Engineers Comments Regarding Surface Water Drainage

Application Reference:	BE/40/26/DOC	Reviewer Reference:	EXT/02
Planning Officer:	Simon Brooksbank	Date of Review:	09/07/2026
Site Name:	Chalcroft Nurseries Chalcraft Lane Bersted PO21 5TS		
Application Description:	Application under Section 73 for the variation of condition imposed under BE/81/20/OUT relating to condition 3 -approved plans and 18-access (conditions further amended by BE/77/25/NMA) BE/13/24/S73 Conditions(s) 22 - surface water drainage 23 - maintenance and management of surface water drainage		
Assessment Number:	1

Application Reference: BE/40/26/DOC Site Name: Chalcroft Nurseries Chalcroft Lane Bersted PO21 5TS	Initial Issue Date: 09/07/26 Issue Date: 09/07/26 Reviewer Reference: EXT/02
---	--

CLIENT		Chalcroft Associates LLP	
PROJECT		Chalcroft Nursery, Bersted	
TITLE		Site Layout - Drainage And Levels	
DRAWN		DATE	PROJECT NO.
A Davies		May 2026	24123
ENGINEER		CHECKED	DRG NO.
S Doughty		SRD	101
SCALE		1:200 @ A1, 1:400 @ A3

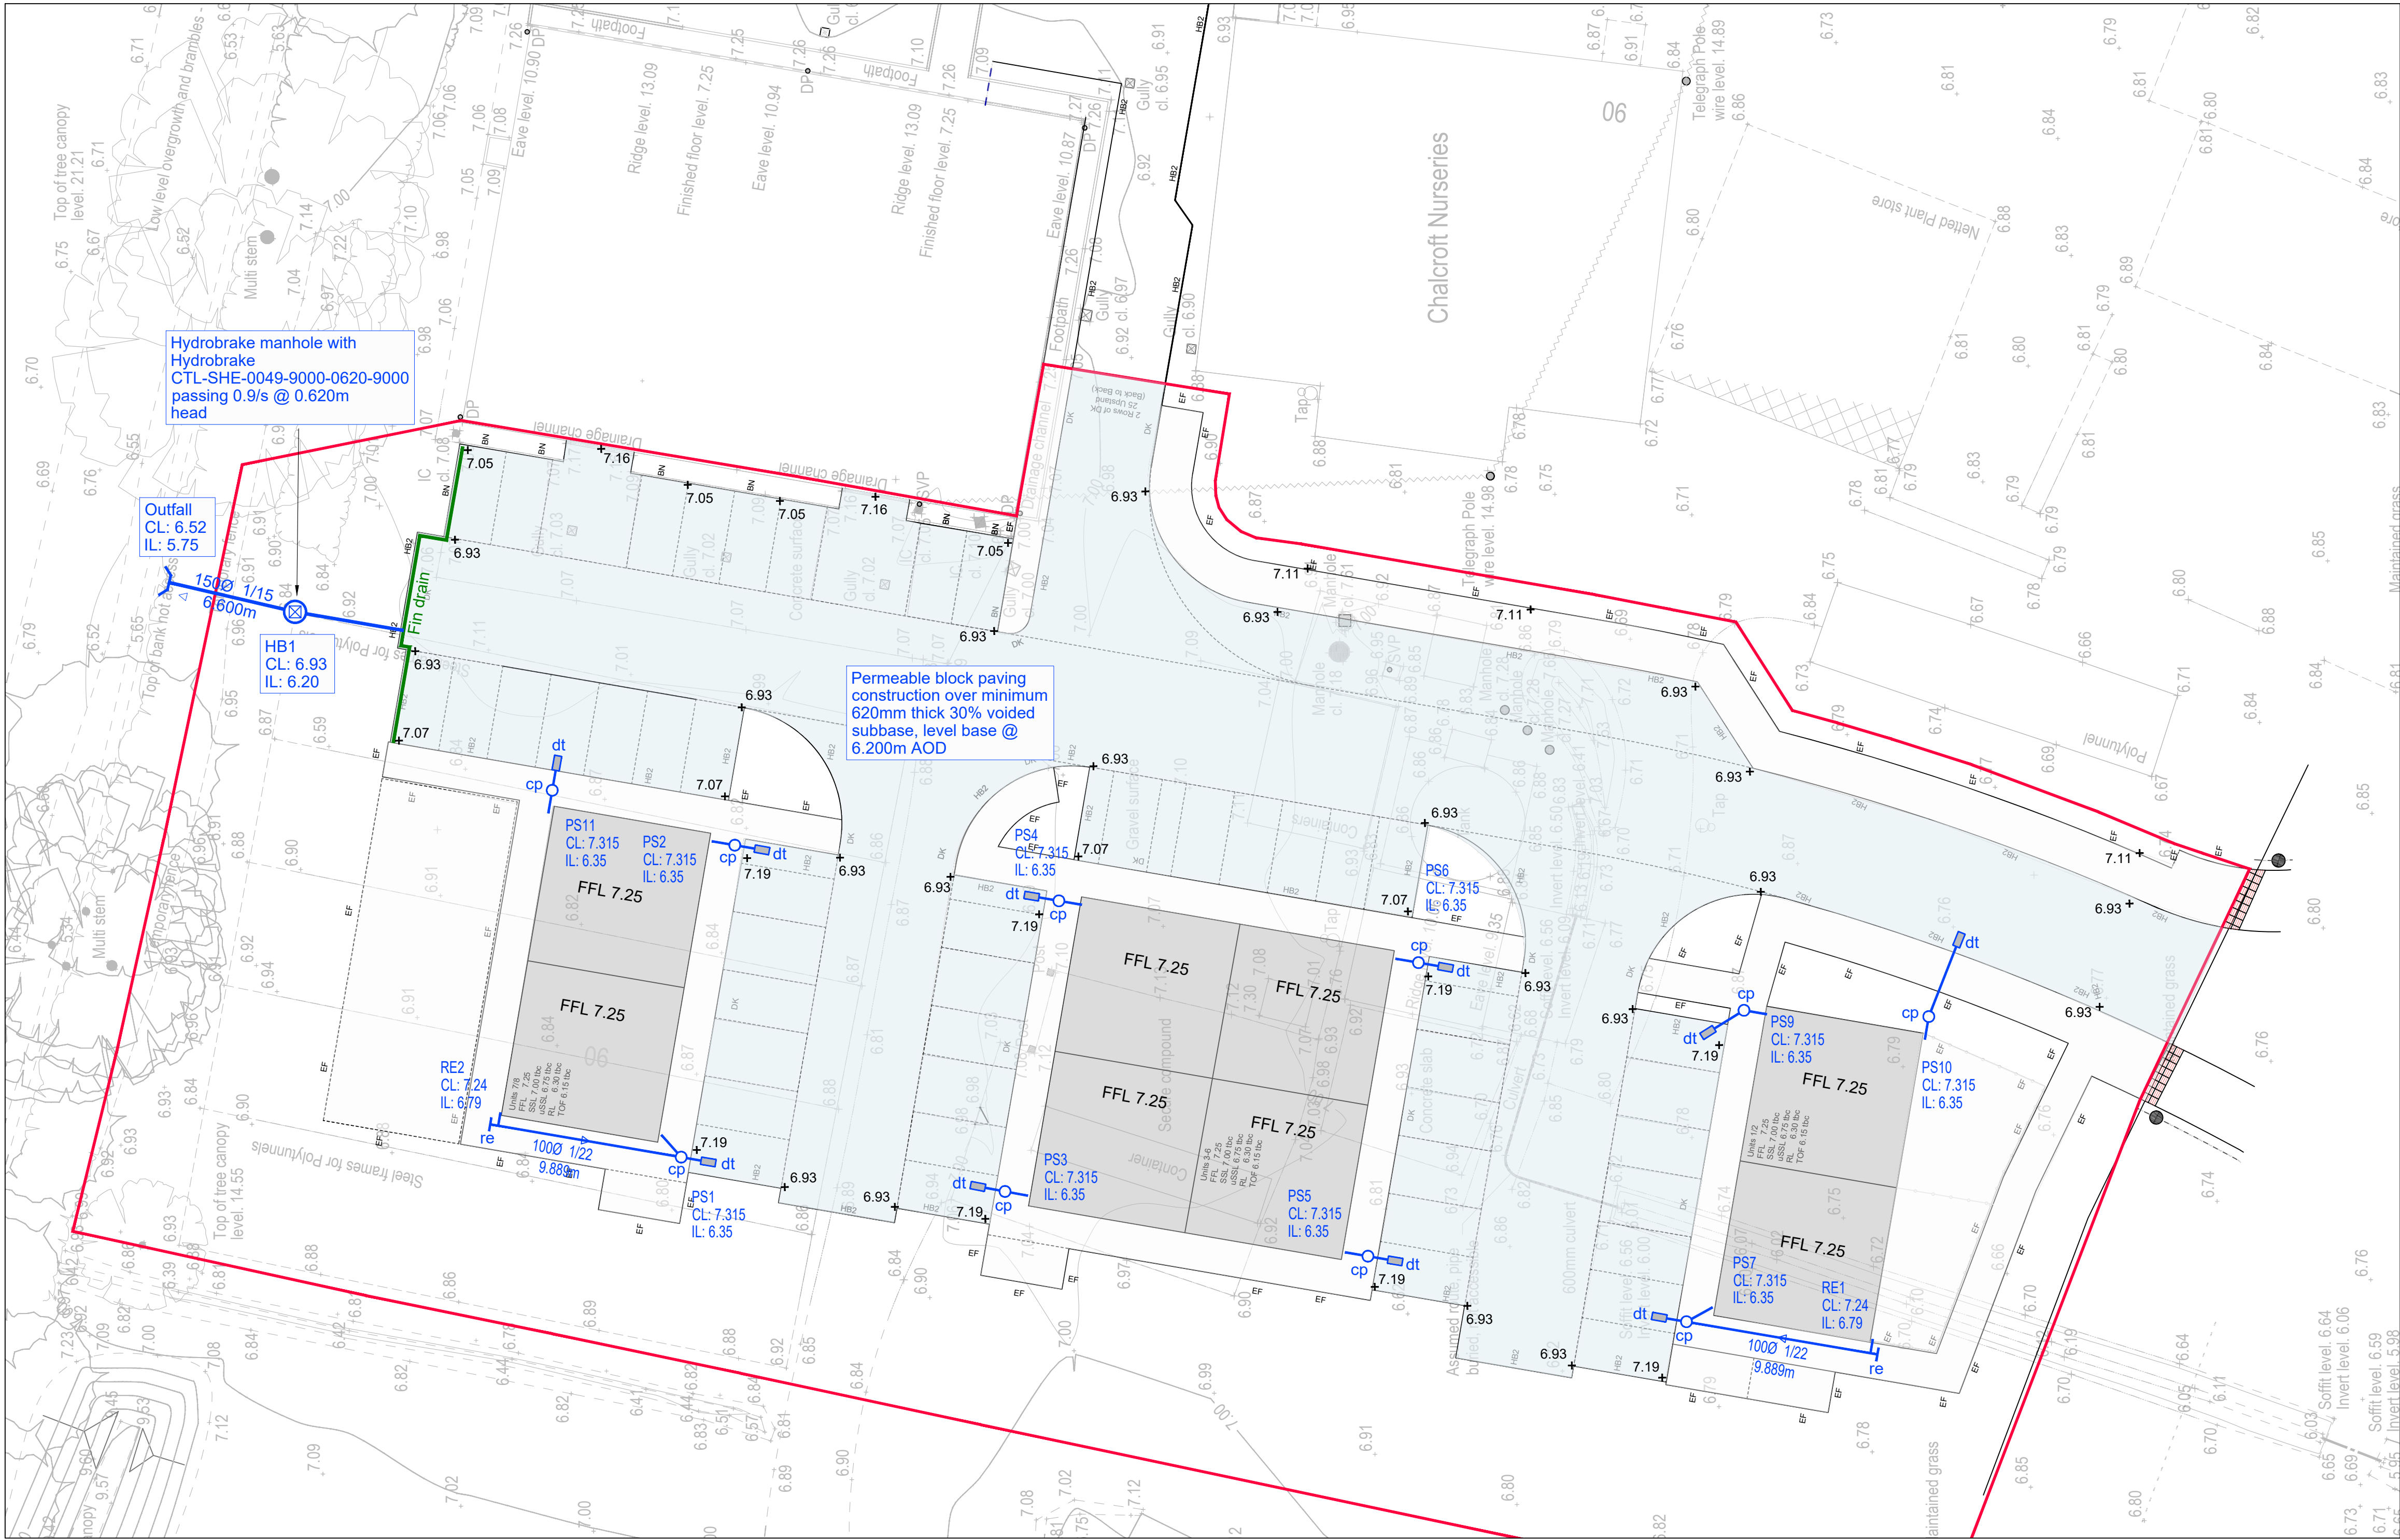
4.	No information has been provided in relation to NSfS Standard 2 - Interception				
5.	Whilst a surcharged outfall has been included in the calculation, it is based on modelling rather than observed depths. In instances where observed depths are not available, the surcharged outfall should be based on top of bank levels. (NSfS Standard 3 – Extreme rainfall)				
6.	An assessment of the proposed discharge volumes has not been included demonstrating that flood risk is not increased (NSfS Standard 3 – Extreme rainfall)				
7.	It has not been demonstrated that surface water flow from elsewhere will be safely conveyed around or through the site without compromising the SuDS system. It is noted from the Flood Maps for Planning that some surface water flood risk is shown which could be an overland flow route from Daffodil Avenue. (NSfS Standard 3 – Extreme rainfall)
